Application No: 15/01326/OUT

Proposal: OUTLINE - Up to 280 dwellings (including up to 30% affordable housing), introduction of structural planting and landscaping, informal public open space and children's play area, surface water flood mitigation and attenuation, vehicle access point from White Post Road, creation of car park and associated ancillary works. All matters to be reserved with the exception of access

Location: OS Parcels 6741 And 5426 West Of Cricket Field North Of Wykham Lane Bodicote Oxfordshire

From: Matthew Parry <Matthew.Parry@Cherwell-DC.gov.uk>
Sent: 10 August 2015 17:35
To: Andy Green
Subject: Land North of Wykham Lane, Banbury - Ref: 15/01326/OUT

Initial Development Framework

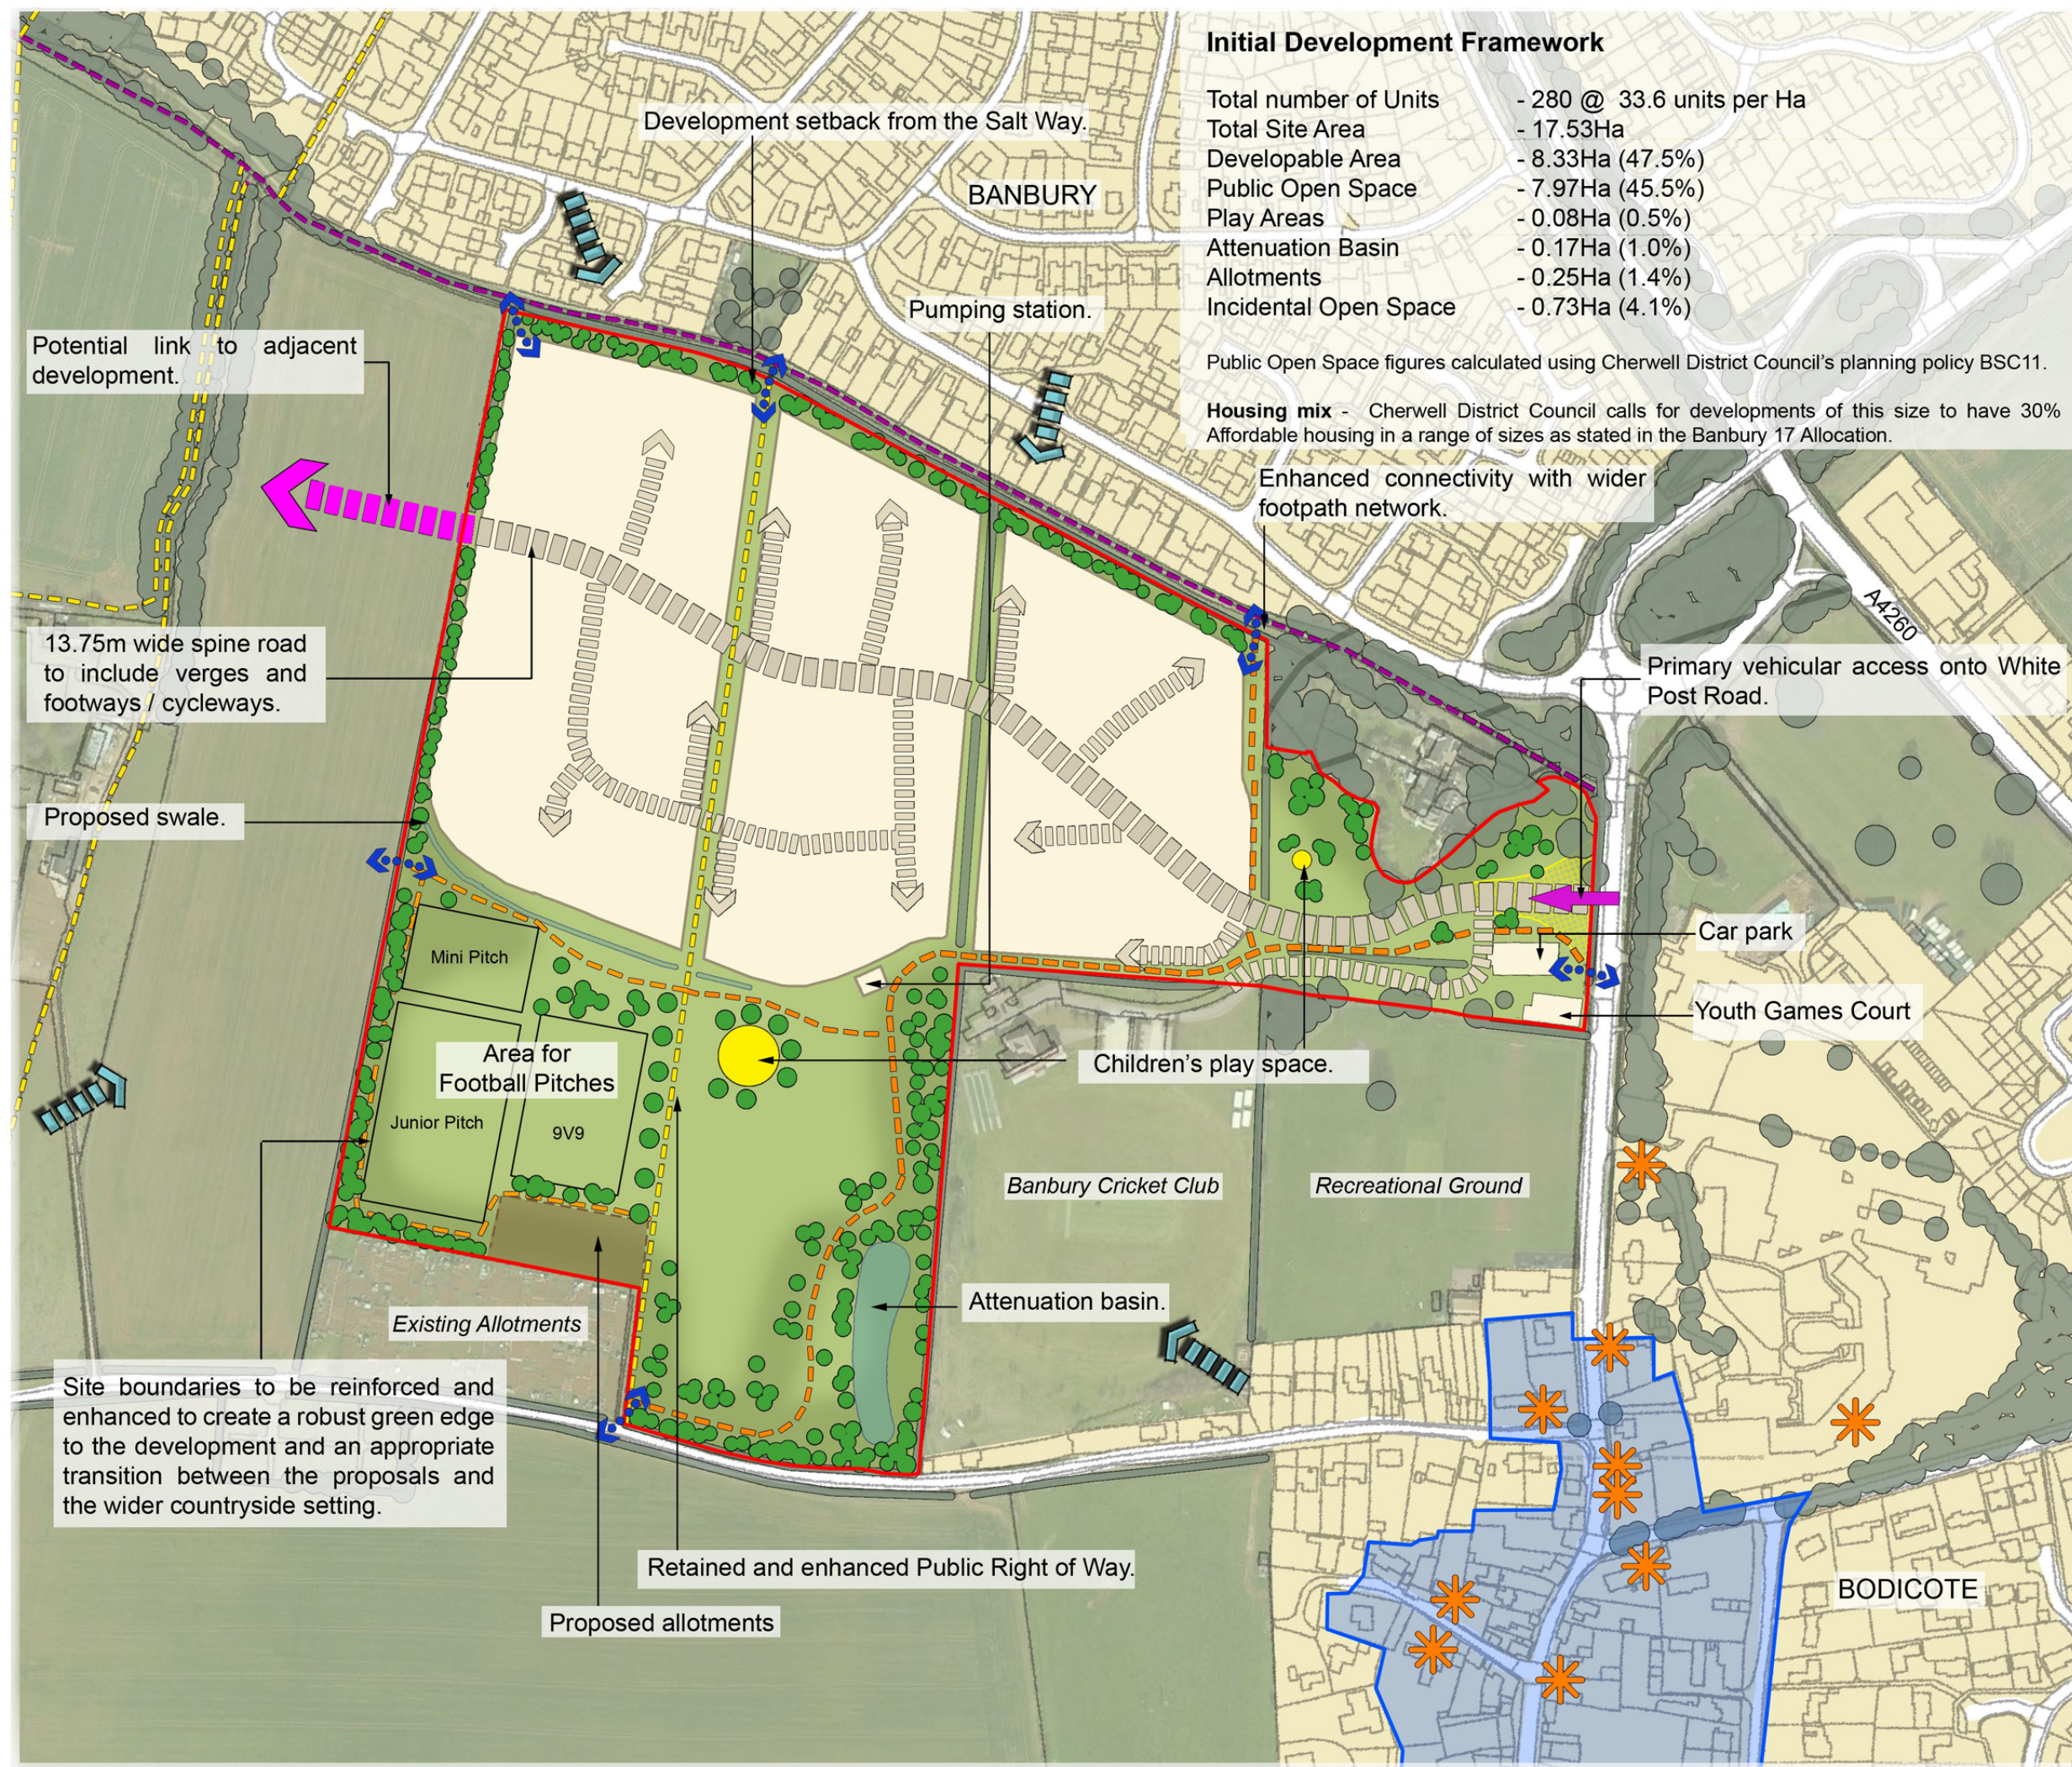
With respect to play areas and recreation facilities, there is no requirement within the site allocation policy or its supporting text for a cricket pitch to be provided. Indeed in applying Policy BSC11 of Local Plan Part 1 the Council would not be looking for a cricket pitch in this location as the open space study for Banbury indicates a shortfall primarily of football pitches (particularly for children). This would result in less formal sports provision being provided on site with the remaining informal green space to protect the setting of Bodicote. The Council has never accepted the management of formal recreational facilities by any party other than the District or Town/Parish Councils themselves and would not support this. All facilities would have to be fully laid and inspected prior to transfer to CDC at nil cost together with a maintenance contribution for the first 15 years. The Council would also normally look for contributions towards future maintenance of SuDS features, on-site trees/hedgerows on public areas as well as public open space itself and play areas where these are to be transferred to CDC. However informal public open space and play areas could be maintained by an agreed management company with an option available for this if required included in the S106 wording. I would suggest a large neighbourhood level play area should be provided (at least 2000sq m) in a suitable location and a handful of informal local play areas too within the built development which are accessible. As discussed, a number of allotment plots are also required which should be located in a sensible position adjacent to the existing allotments. The indicative parameters plan only shows 2 play areas in total which is unlikely to be sufficient. In addition, a meaningful green corridor along the entirety of the public footpath that bisects the site will be expected. This is not shown on the indicative parameters plan at the present time.
